Application: SSI 7485-Mod-2

I write to you to **express my strong objection** to the proposed modification to the M4-M5 Link, Mod 2 The Crescent overpass and changes to pedestrian infrastructure in North Annandale, Rozelle and Rozelle Bay Foreshore area.

Figure 1-1 The revised design

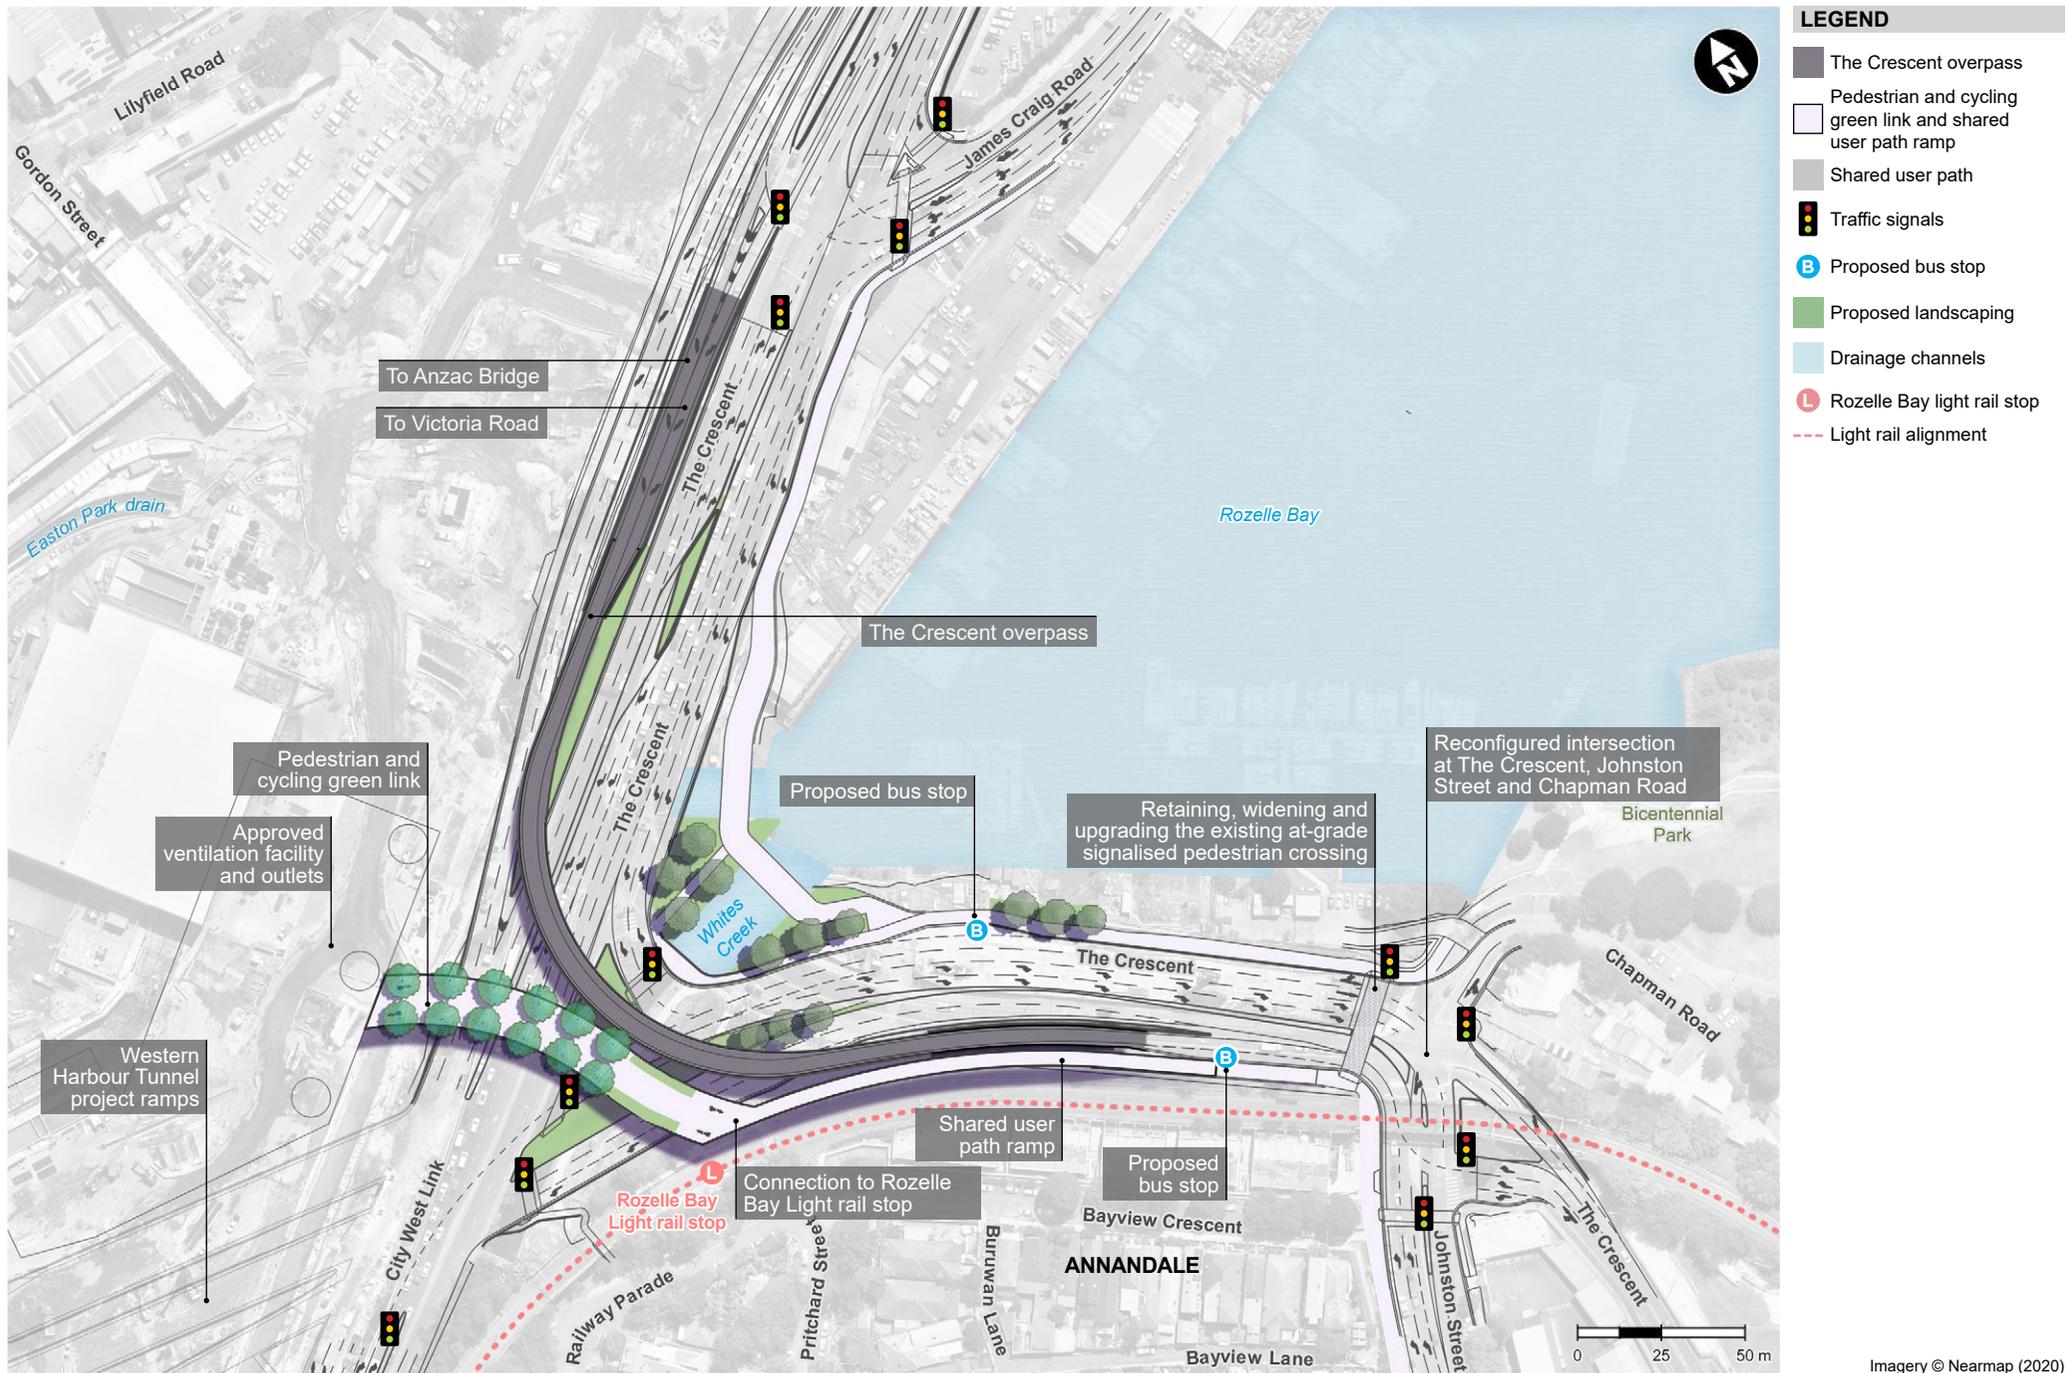
I acknowledge that the revised design has addressed some of my initial concerns regarding pedestrian access to Bicentennial Park from the Annandale area but does not fulfil the commitments of the original consent. Specifically, the project was required to provide a greenlink directly between the new parkland being created as part of the Westconnex project and the existing foreshore parkland of Bicentennial Park. The revised design still does not achieve this however it can be achieved.

An elevated shared path can be constructed at the top of the existing retaining wall on The Crescent adjacent to the light rail line. This elevated path would continue on from the Rozelle Bay Light rail stop before crossing The Crescent before ramping down to Bicentennial Park. I expect that this shared path would be of a very high architectural standard which befits the current and proposed development of the Bays Precinct and not a caged walkway that has previously been proposed. A sketch of the proposed link to Bicentennial Park has been attached to this submission.
